Ribble Valley Borough Council
Housing & Development Control

Application no: **3/2021/0556**

Address: **74 Higher Road Longridge PR3 3SY and land to the rear**

Proposal: **Application for reserved matters consent (appearance, scale, landscaping and layout) pursuant to outline planning consent (ref 3/2016/1082) for the demolition of 74 Higher Road and construction of up to 123 houses on land to the rear.**

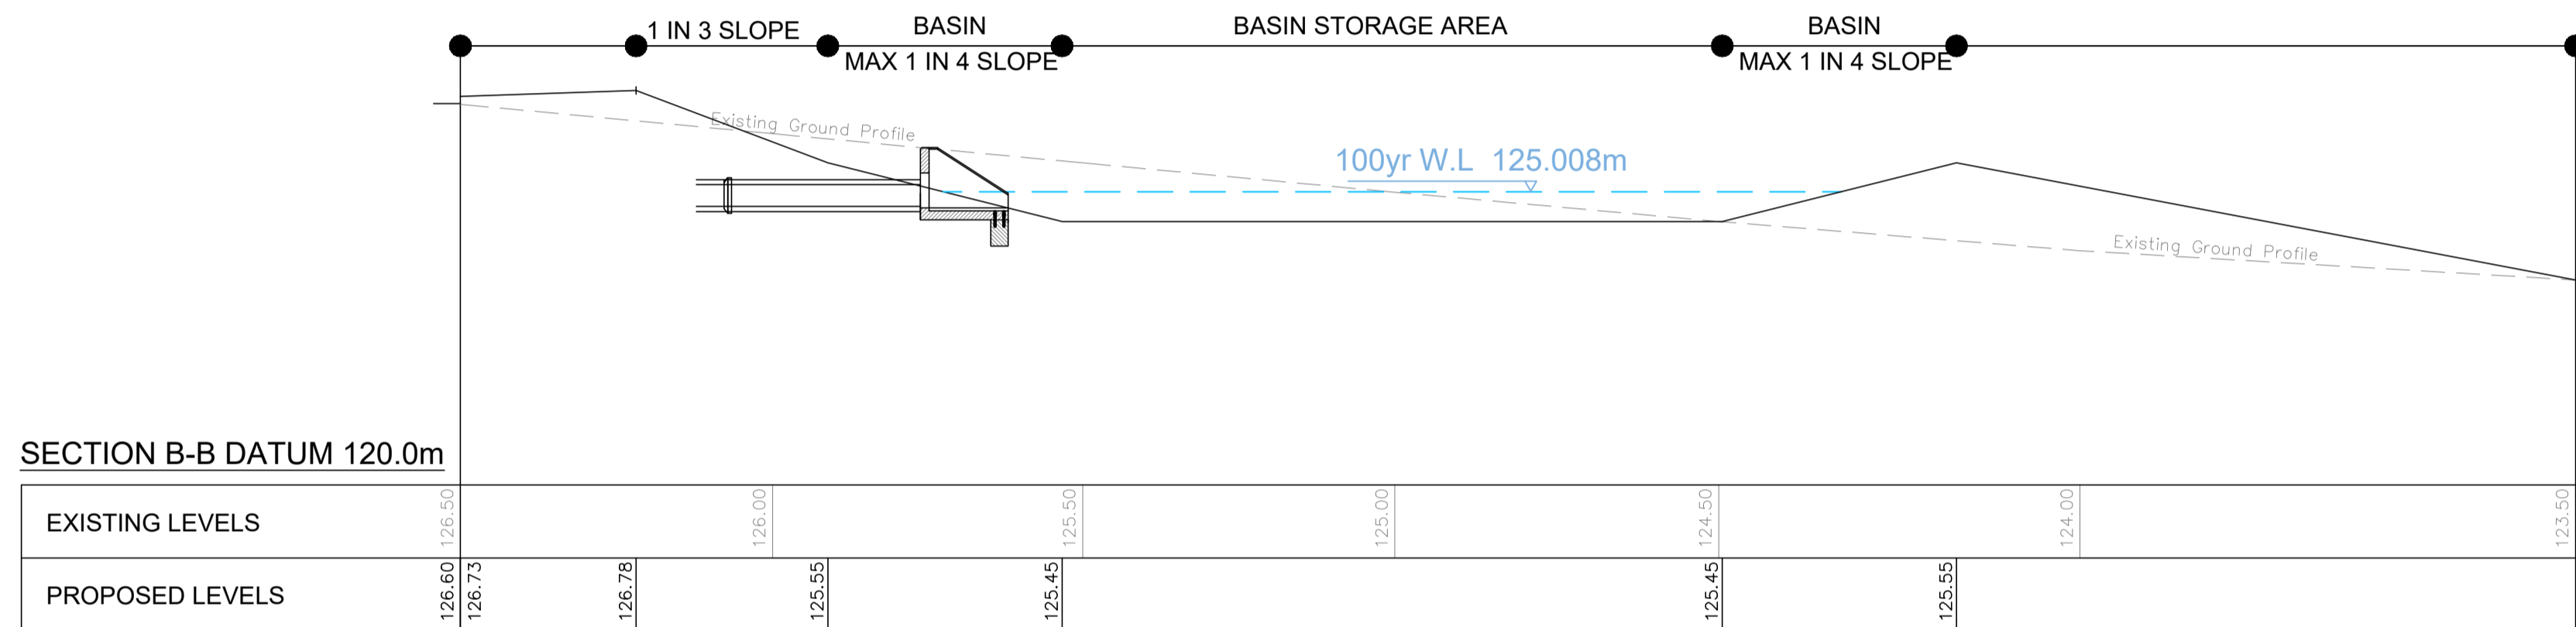
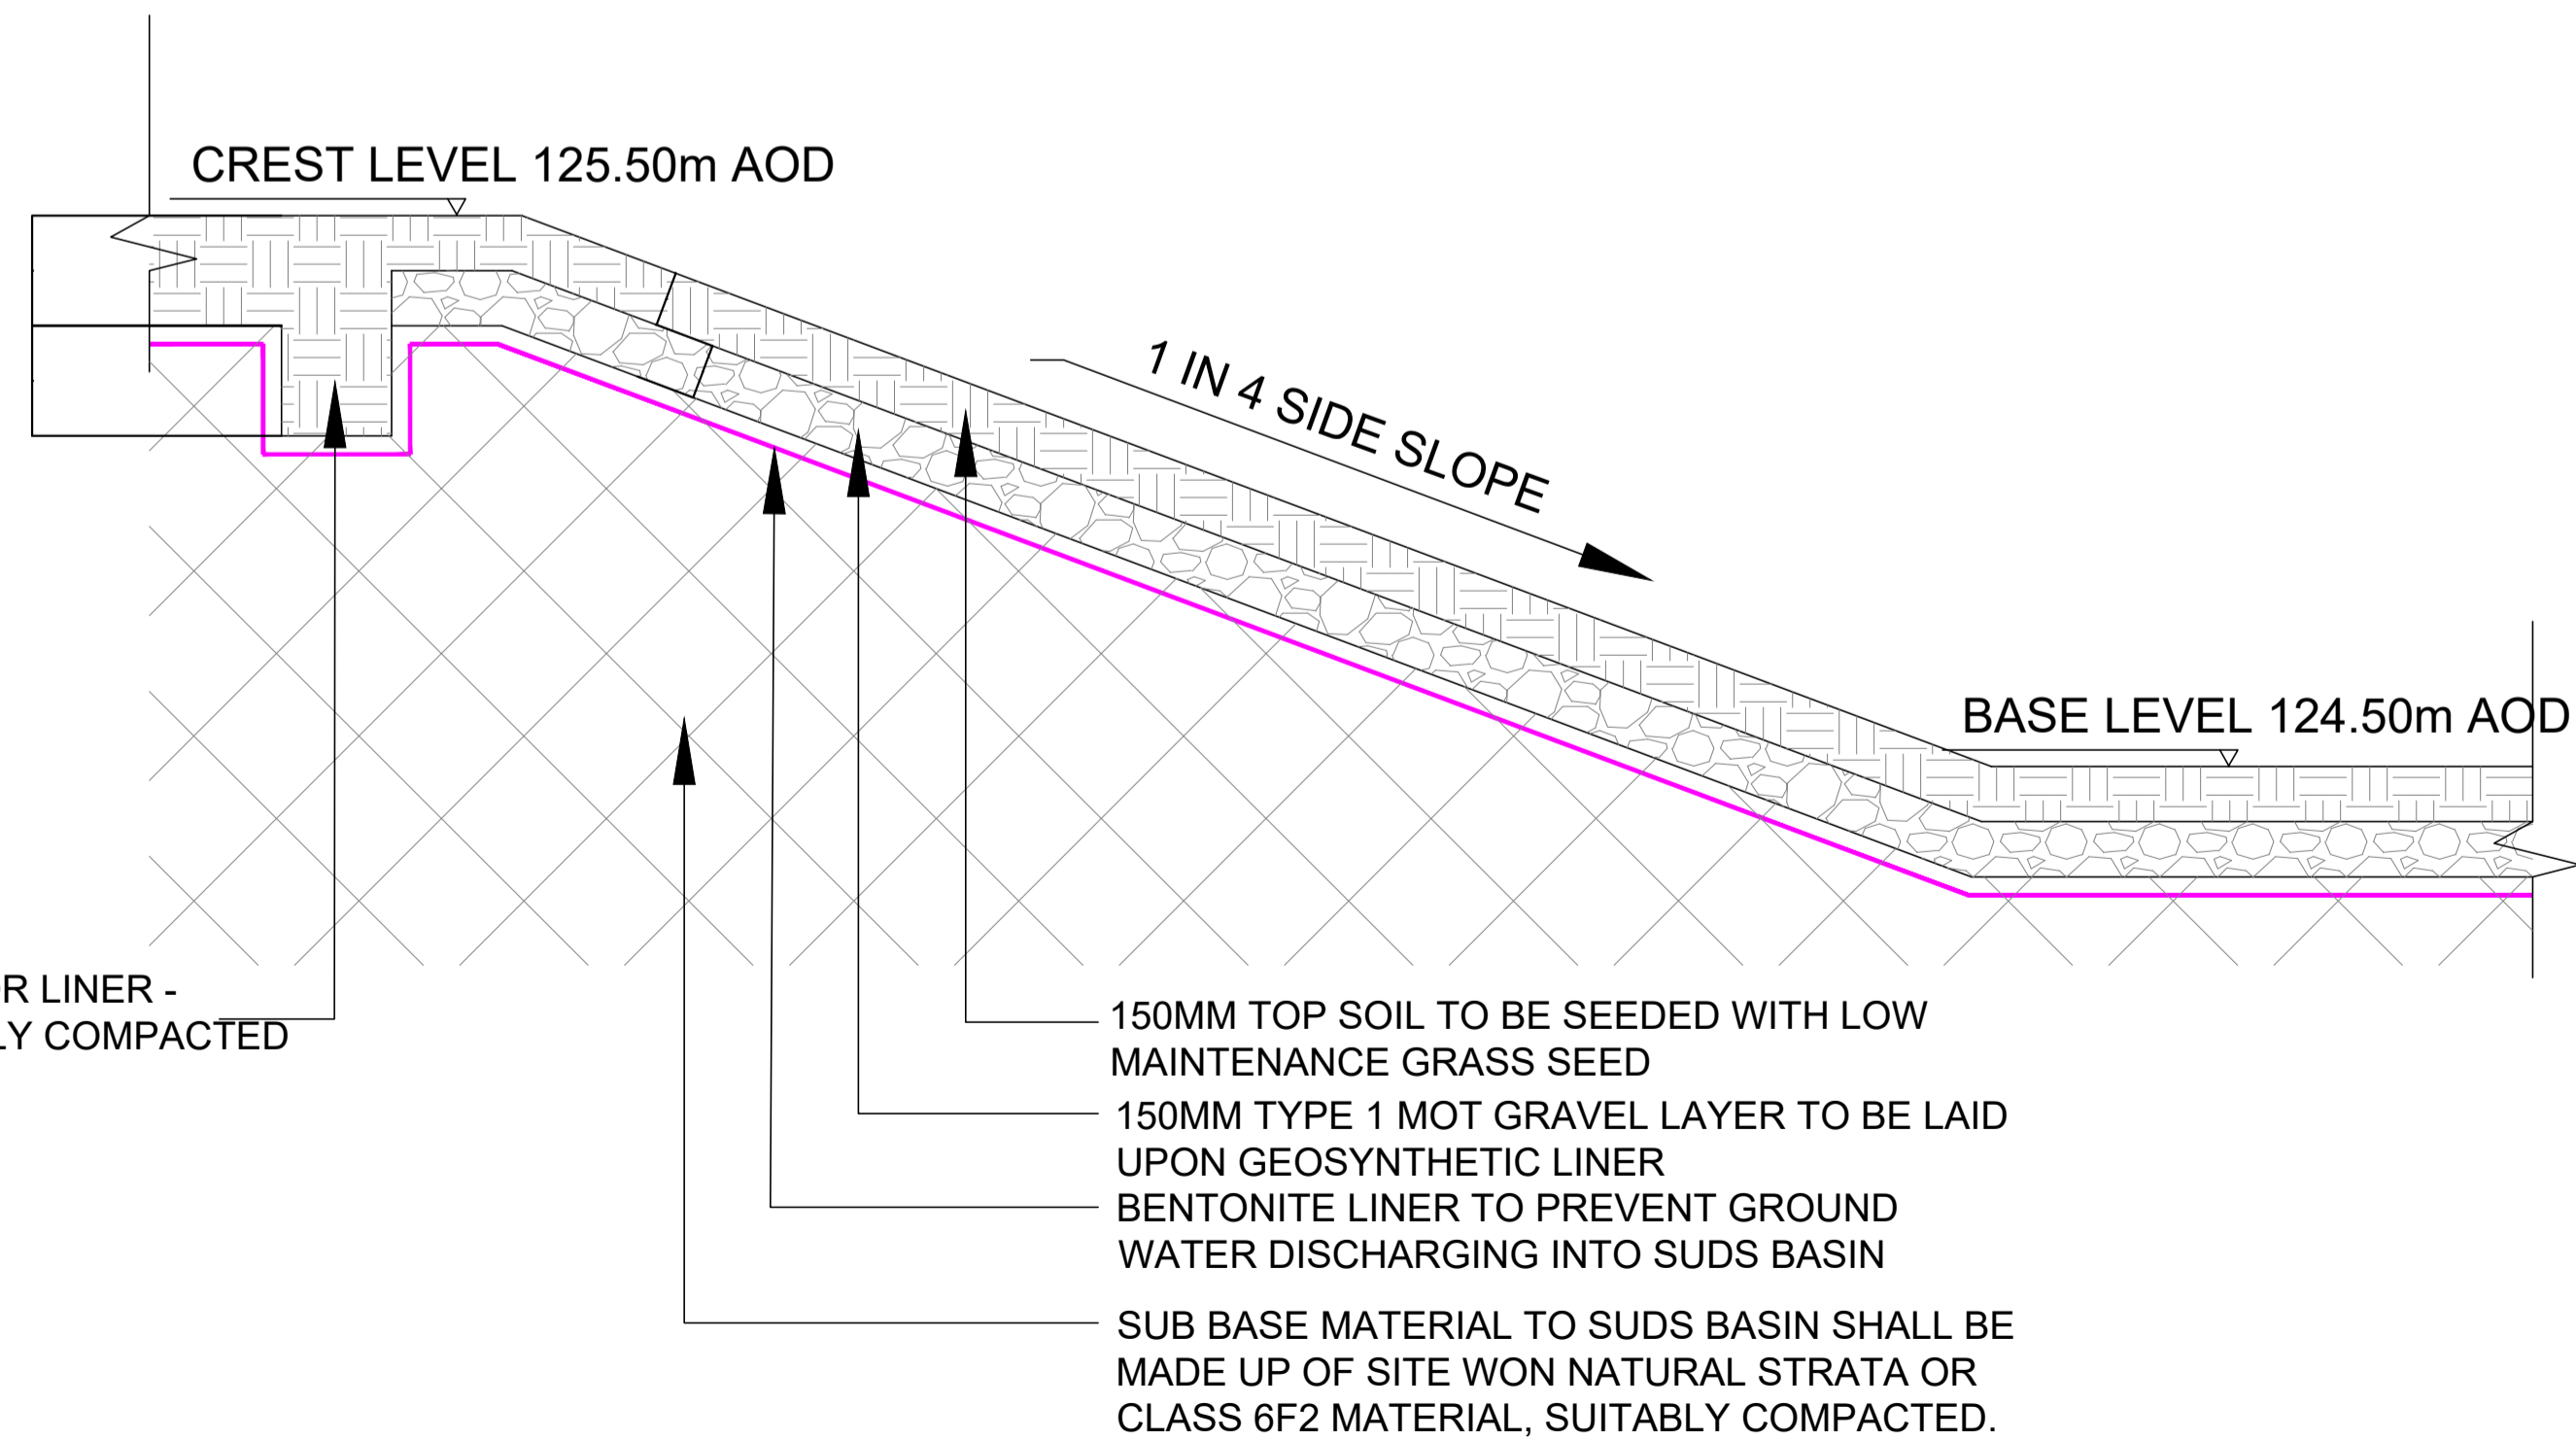
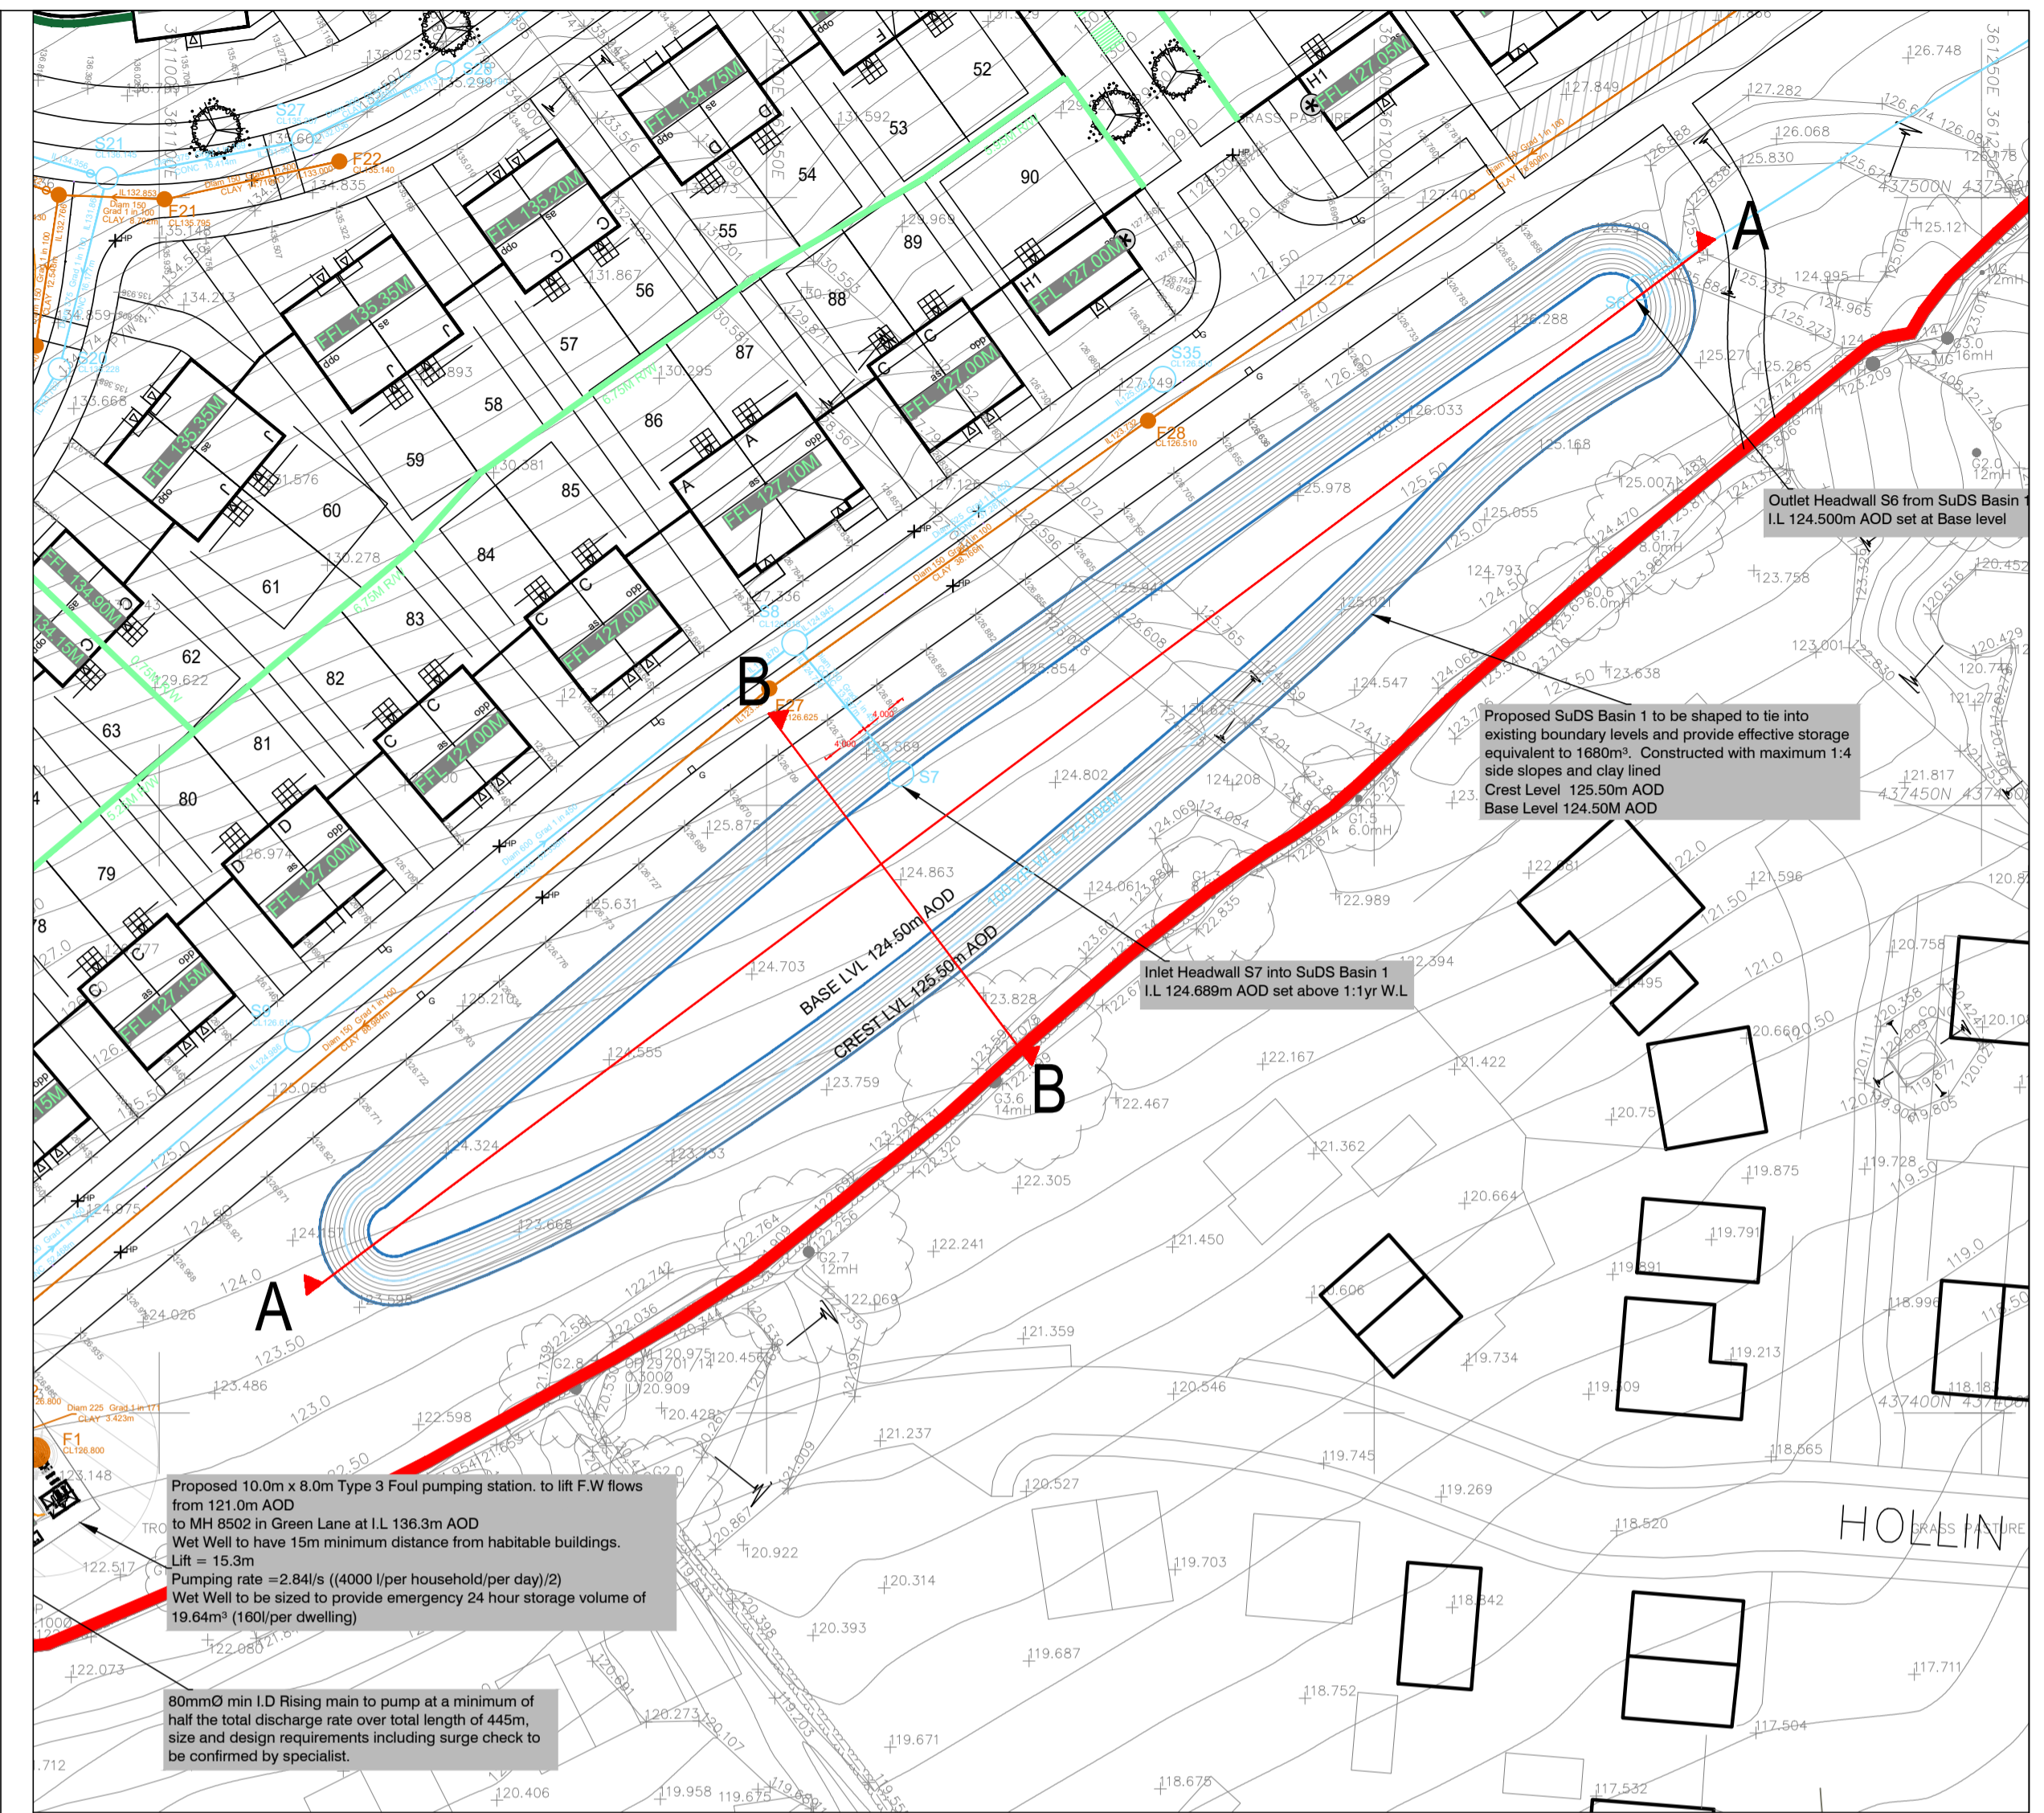
Due to the gradient of the site, the LHA require a Vehicular Restraint Assessment is submitted to the LHA where the carriageway abuts the attenuation basins. This is to ensure that vehicles have a safe passage where the gradient is at its steepest.
